DeYOUNG SUBDIVISION Construction Drawings El Paso County, Colorado

TITLE SHEET

PCD PROJECT NO. MS-20-001

SHEET: C1.1

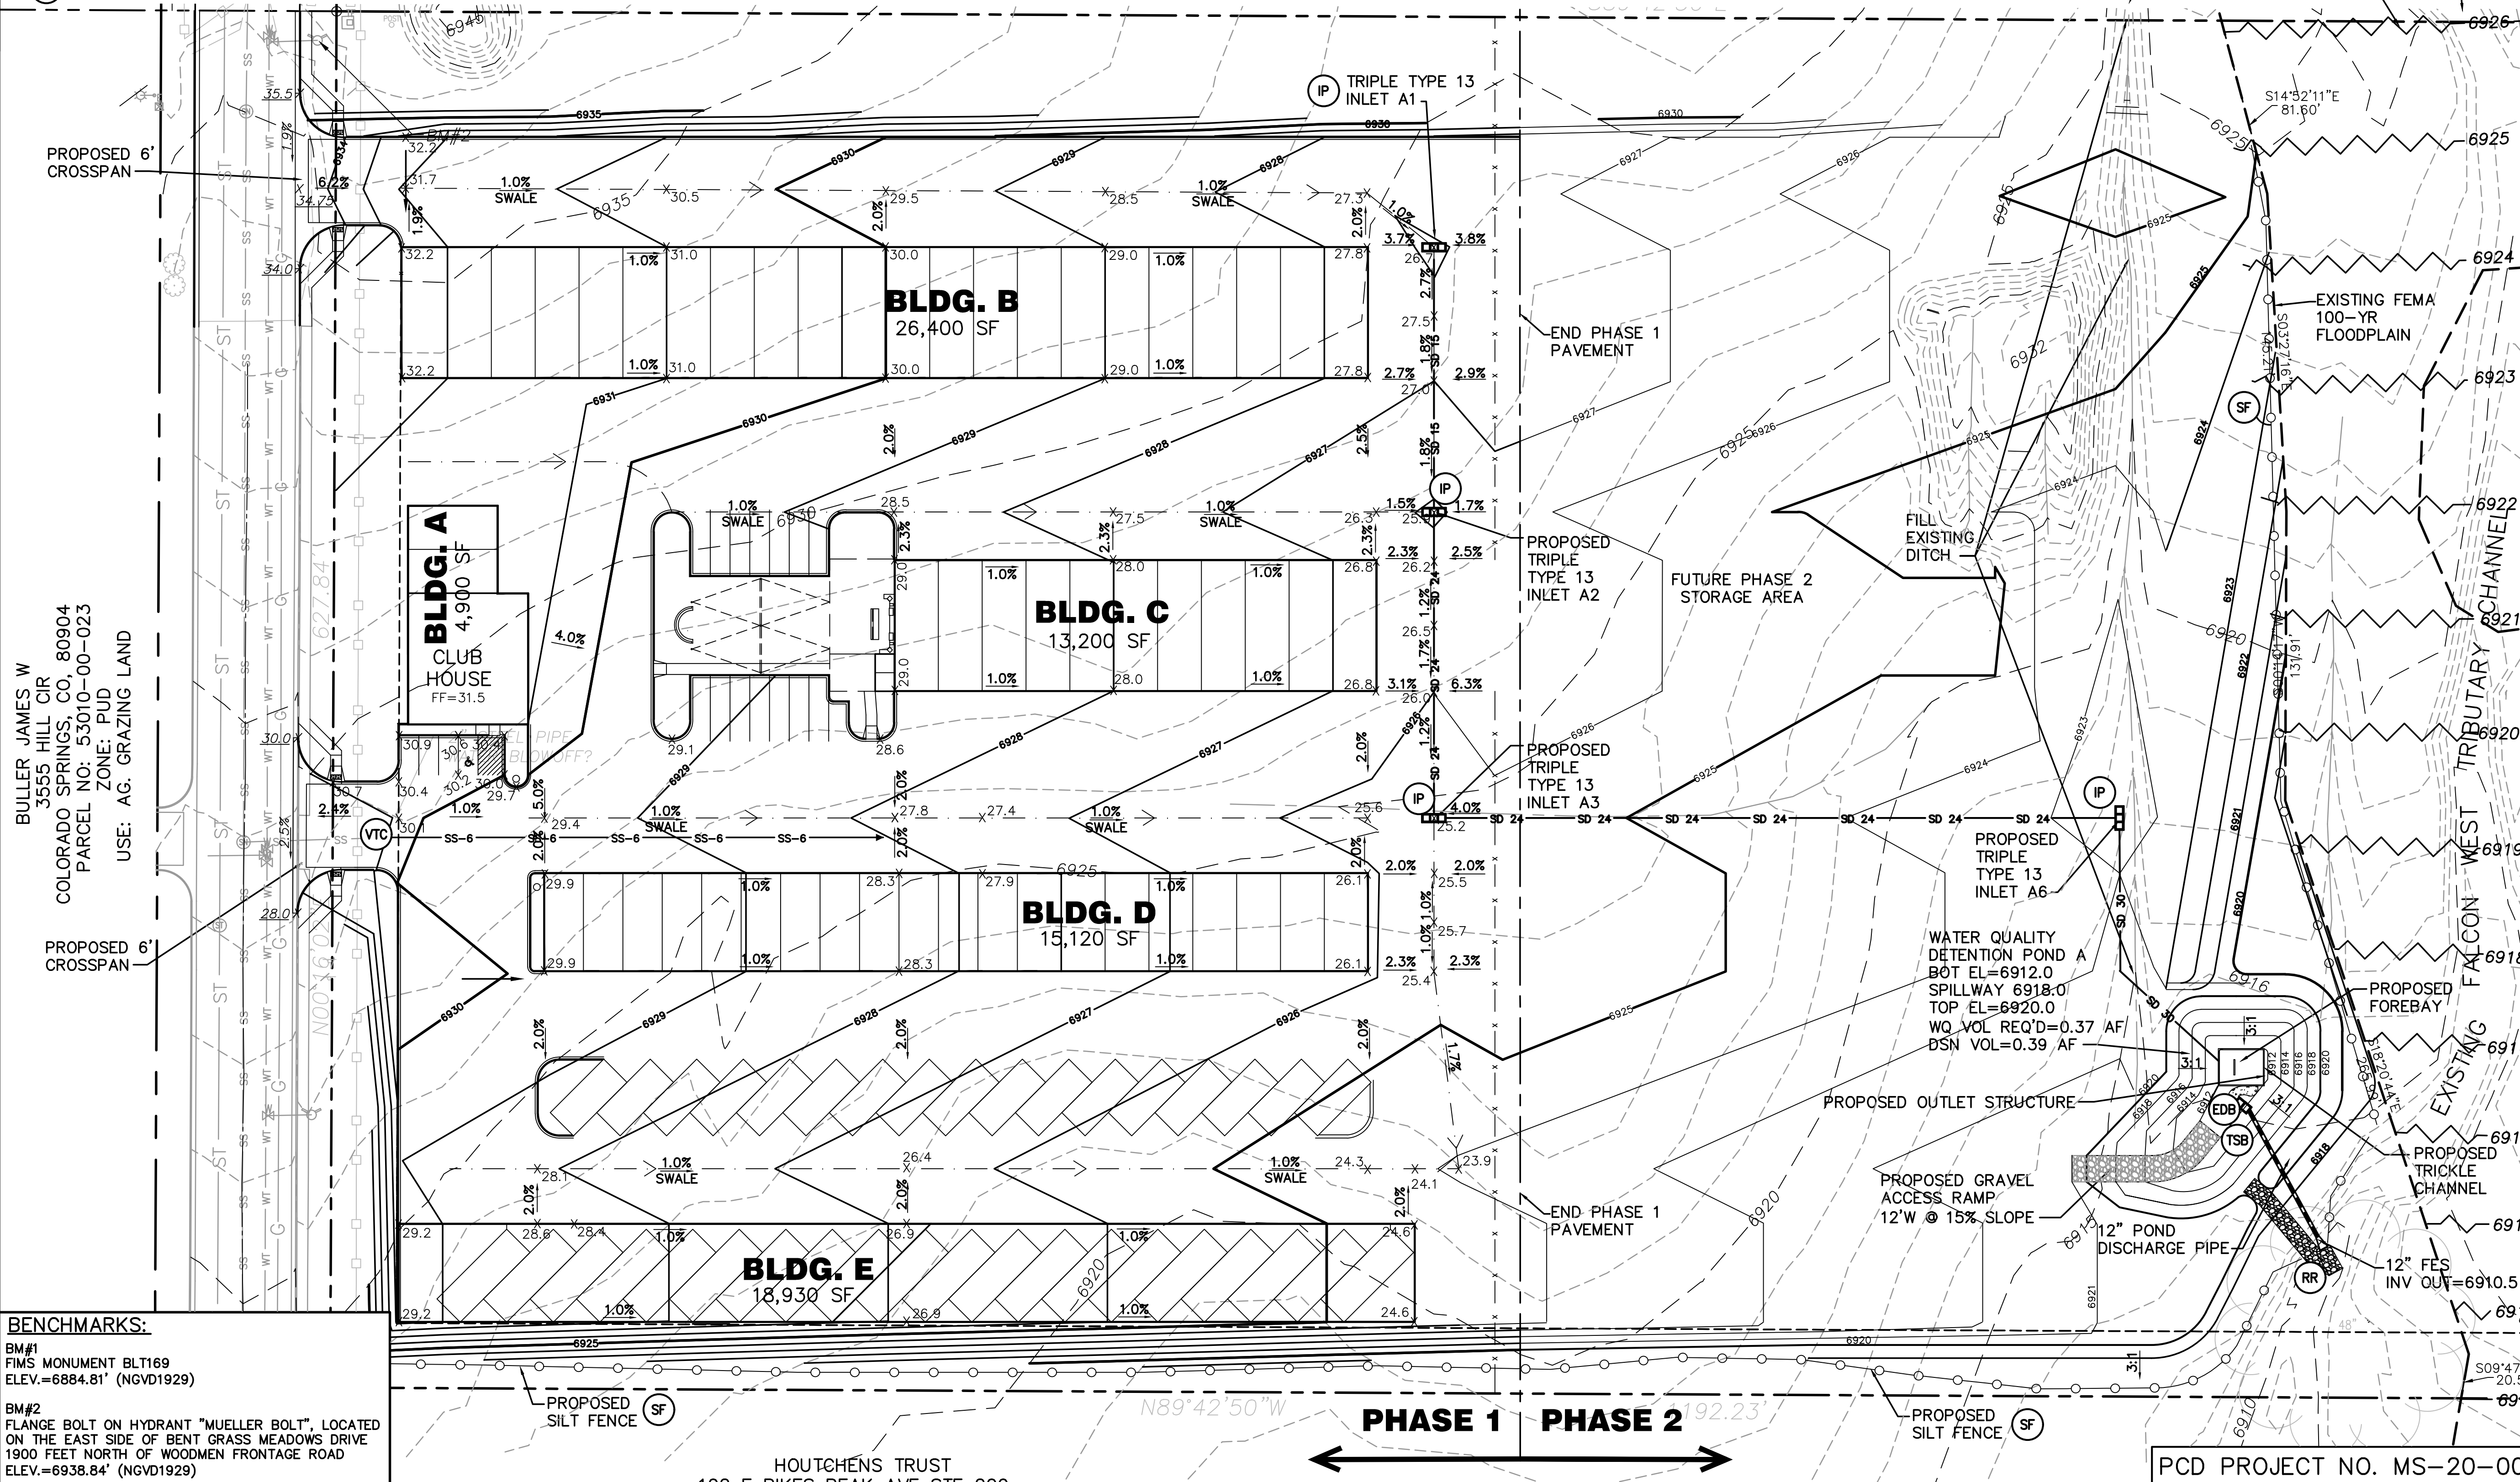
show areas of cut/fill

Add line type to legend and/or use gray type because its not a grading contour

adjust text
